East Anglia One North (EA1N) and East Anglia Two (EA2) Offshore Wind Farms

Planning Inspectorate Reference: EA1N – EN010077, EA2 – EN010078

Deadline 9 – 15 April 2021

Comments of Suffolk County Council as Lead Local Flood Authority

TYPICAL INFILTRATION BASIN CROSS SECTION

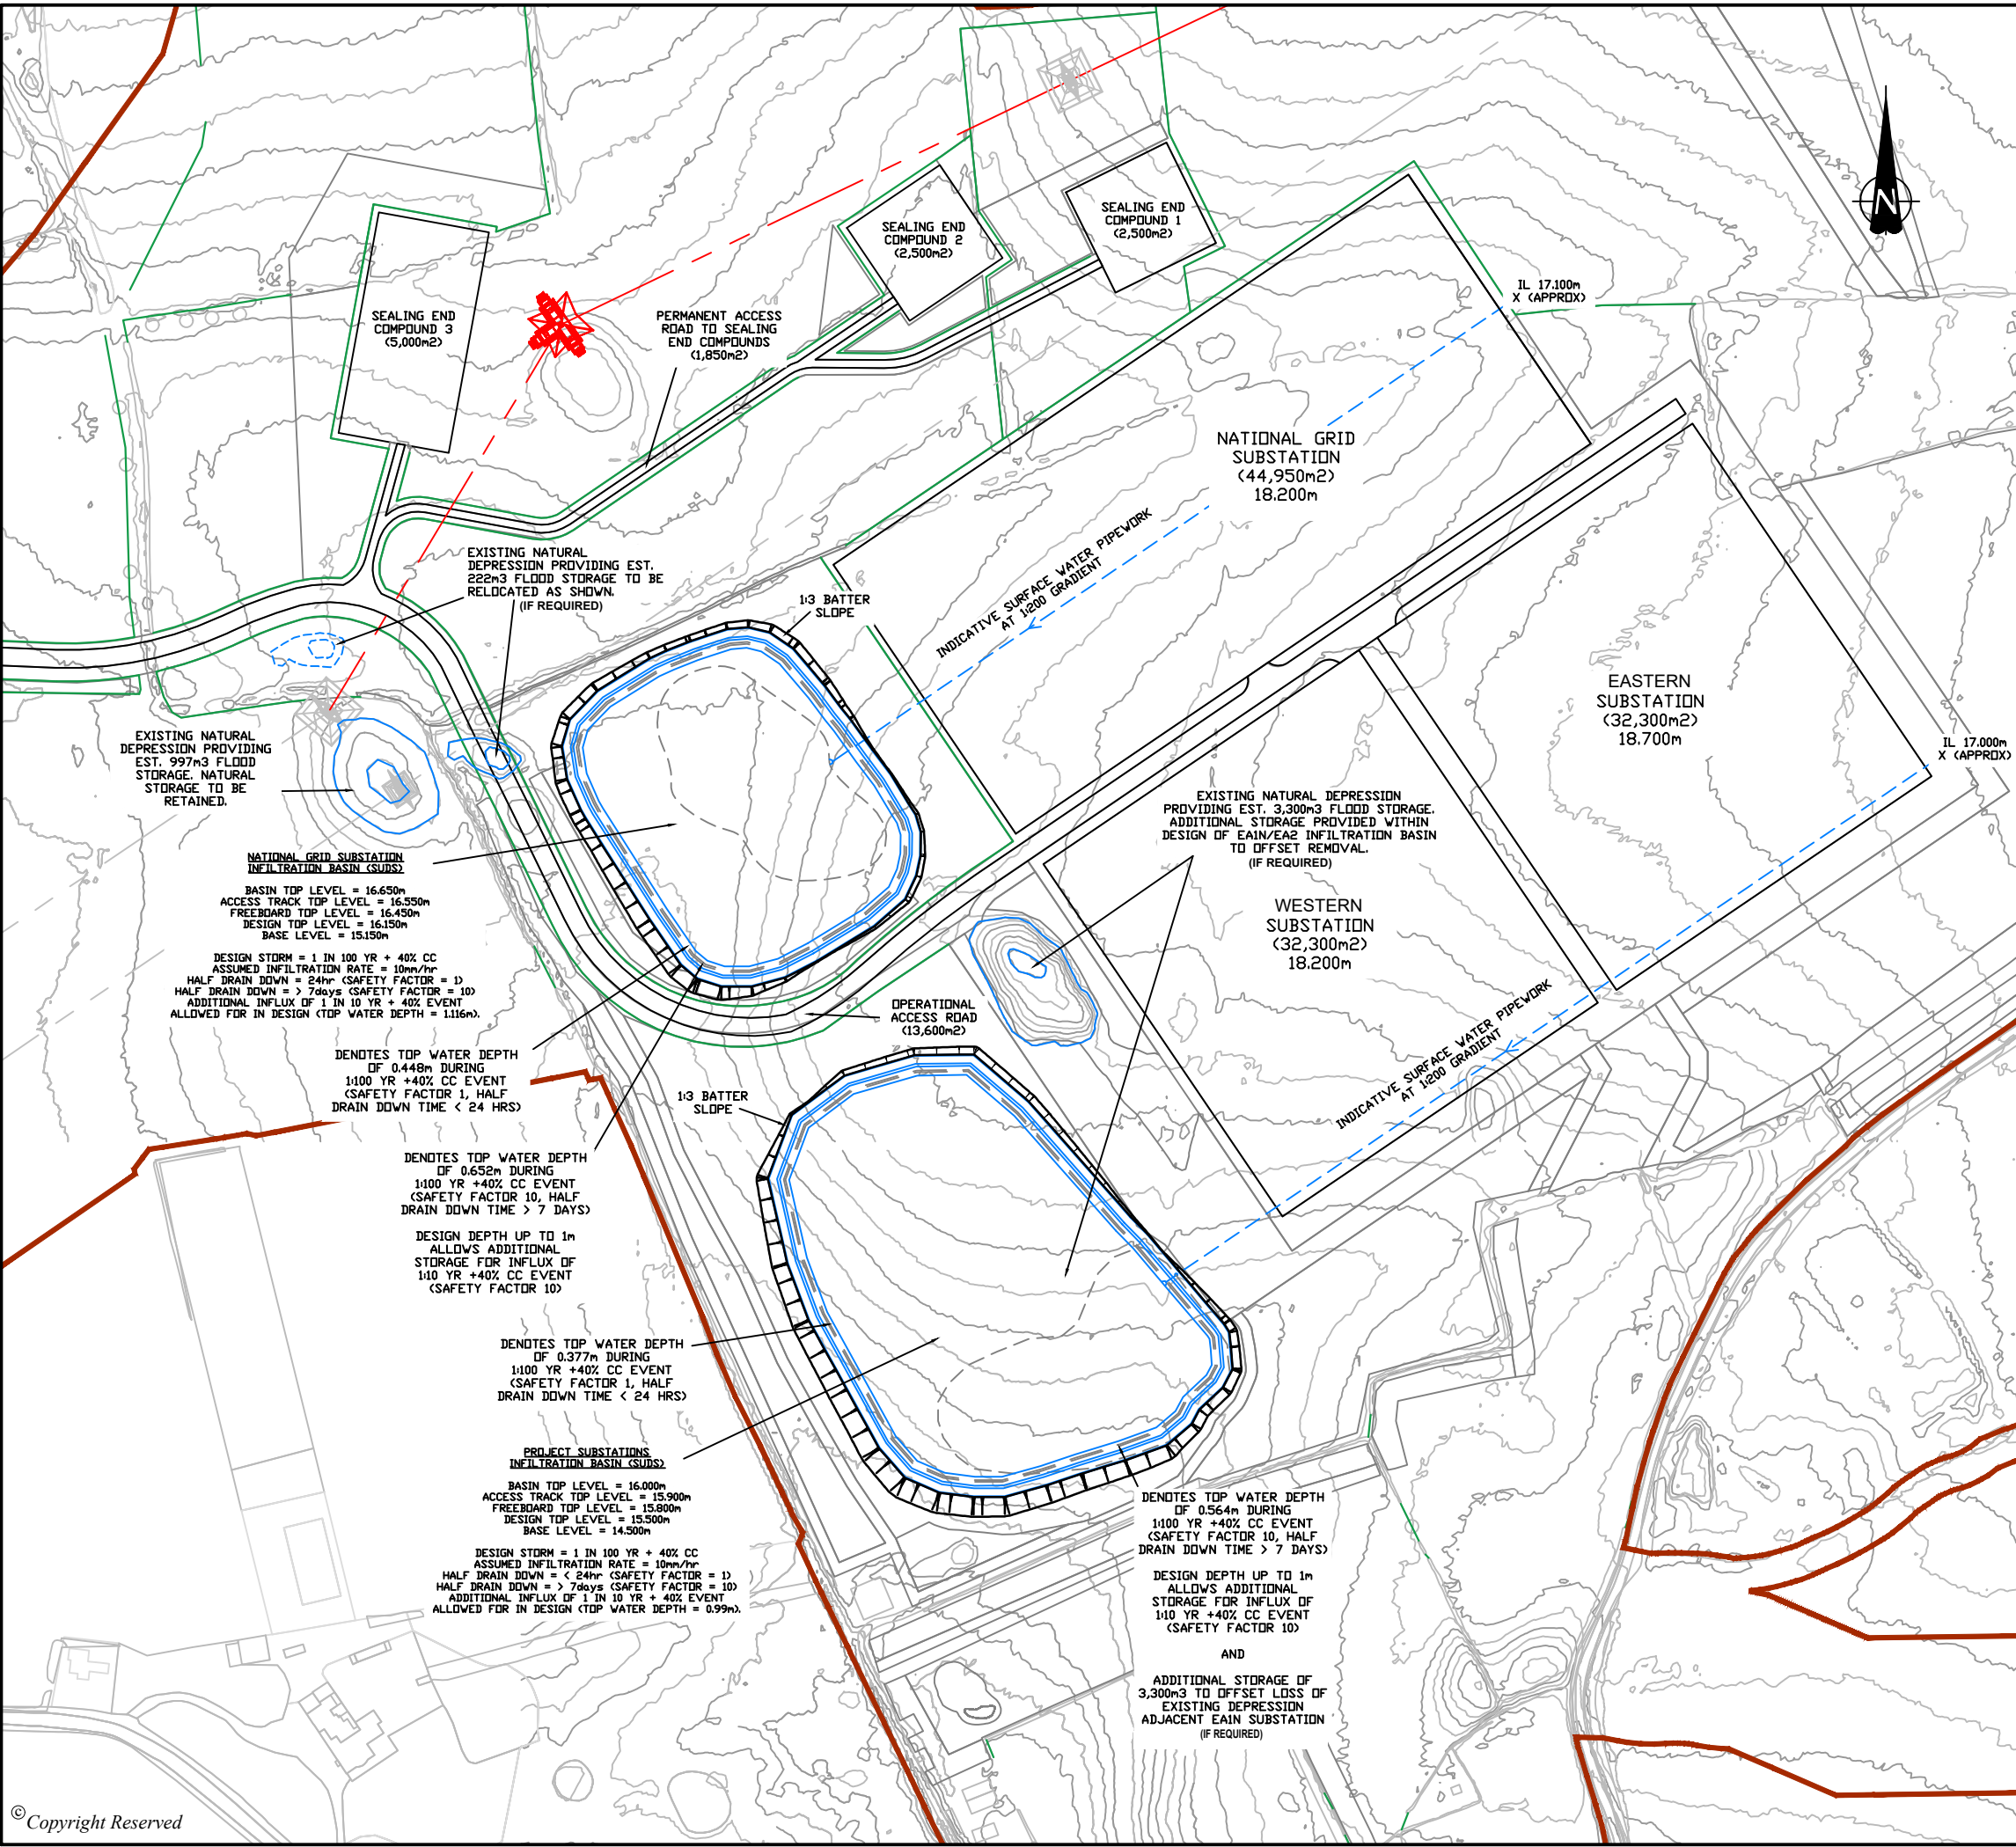
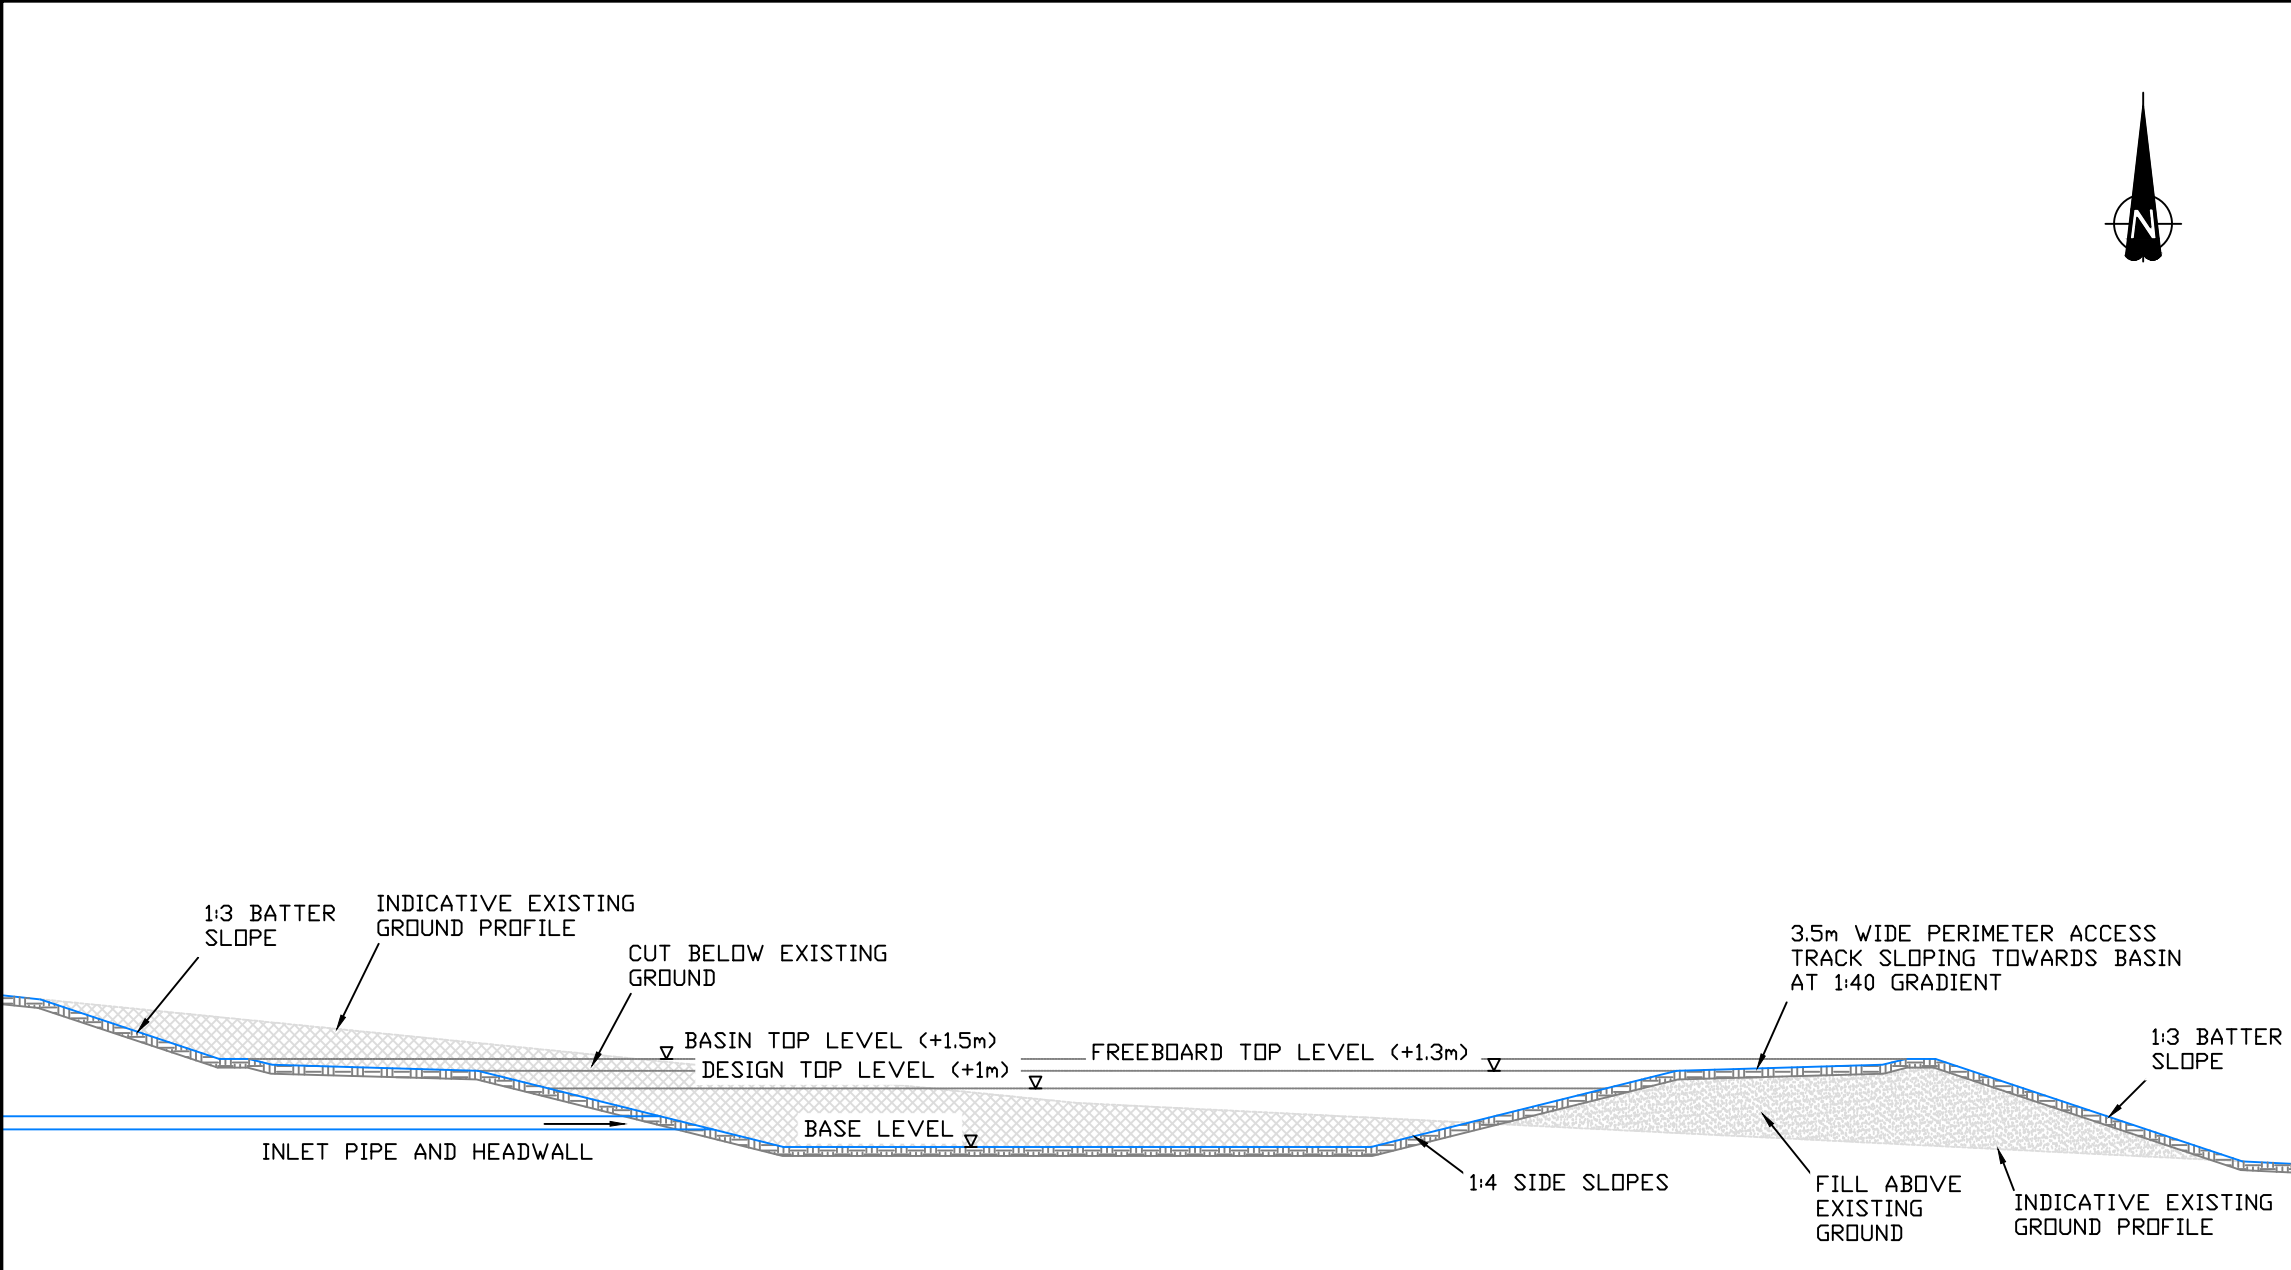
155	When looking at both of the assessments undertaken within section 6.3, it has been confirmed that for both the 1 in 100 year storm event and a 1 in 10 year storm event 24 hours after an initial 1 in 100 year storm event, using an infiltration rate of 10mm/hr, the 24 hour half drain time cannot be achieved.	See response to paragraph 156.
156	Therefore, this model has proved that an infiltration rate of 10mm/hr would mean that an infiltration only design for the site is unviable	As per previous representation from SCC, including at Deadline 8, the assessment undertaken by the Applicant (1:100+40% + 1:10+40%) is acceptable to demonstrate there is sufficient storage in the design for a subsequent rainfall event, despite the basin not half draining within 24 hours.

<p><u>This is a design check pass.</u></p> <p>The Applicants continued statement that this makes an infiltration only approach unviable is not correct. See also SCC's further comments (below) at ID24 of the response to the Applicant's comments (REP8-046) on SCC's submissions at Deadline 7.</p>
158	As the assumed infiltration rate of 10mm/hr indicates an infiltration only scheme to currently be unviable, the Applicant presents a scheme utilising both infiltration and attenuation as well as an attenuation only scheme. This is in line with the SuDS drainage hierarchy (SCC, 2018), discussed in section 6.1.	<p>No justification or evidence provided as to why this is unviable, other than the half drain point, discussed above.</p> <p>If this is the only reason (no other reason stated in section 6.1), then why is the below approach acceptable for the hybrid option? See below response to paragraph 170.</p>

N/A	N/A	The Applicant has demonstrated that an infiltration only scheme is viable. The half drain checks are considered a design pass. The plan provided in Appendix 4 demonstrates that an infiltration only option is technically feasible and deliverable within the Order Limits when considered in isolation.
170	As the 24 hour drain time was not viable the Applicant assessed the storage required for a secondary 1 in 10 year storm event (plus 40% climate change scenario), 24 hours after the initial 1 in 100 year (plus 40% climate change scenario) storm event, as requested by SCC. By adopting these parameters it has been confirmed that sufficient storage can be provided within the Order Limits for the hybrid scheme.	<p>The Applicant acknowledges that this design (hybrid option) also does not half drain within 24 hours, and as such have added an additional 1:10+40% rainfall event.</p> <p>This is the same approach used for infiltration only.</p> <p>However, for this approach, the Applicant has not concluded that this option is unviable, despite the</p>

<p>same methodology and the same result (in terms of half drain times) as for the infiltration only approach.</p>
<p>Table 6.2 & Table 7.2</p>		<p>The total storage volumes provided for the infiltration only and hybrid options are as follows:</p> <p>Infiltration only = 37,388m³ Hybrid = 36,913m³</p> <p>Based on the above numbers, from their respective Tables, the Hybrid solution only results in a 1.28% reduction in attenuation volume provided.</p> <p>However, based on the Tables provided in the Appendices, which provides details on the plan areas of the basins, there would be a 34.6% reduction in plan area for the Project substations and a 34.7% reduction for the National Grid basin for the hybrid option, when compared against the infiltration only option.</p> <p>Such a significant reduction in land take, despite only a minor reduction in attenuation volume required is achieved by increasing the depth of the basins for the hybrid solution.</p> <p>The hybrid solution utilises basins with a water depth of 1.5m and a total depth of 2.0m. Both the infiltration only and attenuation design options accommodate basins with a maximum water depth of 1.0m and a maximum total depth of 1.5m, as per CIRIA SuDS Manual design guidance.</p>

<p>Therefore, the reduction in land take illustrated in Appendix 6 is inaccurate as it does not comply with National Design Guidance, specifically CIRIA SuDS Manual.</p> <p>Note to ExA: You can see this difference without digging into the calculations. Compare the plans in Appendices 4,6 & 8. Note the difference between the base level and the basin top level for each basin in each design option. You can make the same comparison using the maximum water level.</p>
190	<p>As discussed in section 6, although an infiltration only scheme is currently proving unviable due to the worst case 10mm/hr infiltration rate assumed, this is a worst-case scenario and is likely to change once percolation testing has been undertaken. If an infiltration only design proves viable once percolation testing has been undertaken and ground water levels are established, it will be implemented as the final SuDS design.</p>	<p>Yellow - In section 6, the only possible reason stated for infiltration being unviable, is due to the half drain times, which as above, is an incorrect conclusion. No further evidence has been provided in Section 6 to justify any other reason for the infiltration only method to be unviable, despite what was discussed at ISH11.</p> <p>Cyan – This does not make reference to the other potential issues that could present a barrier to an infiltration only approach, as discussed at ISH11 and stated elsewhere in this document.</p>
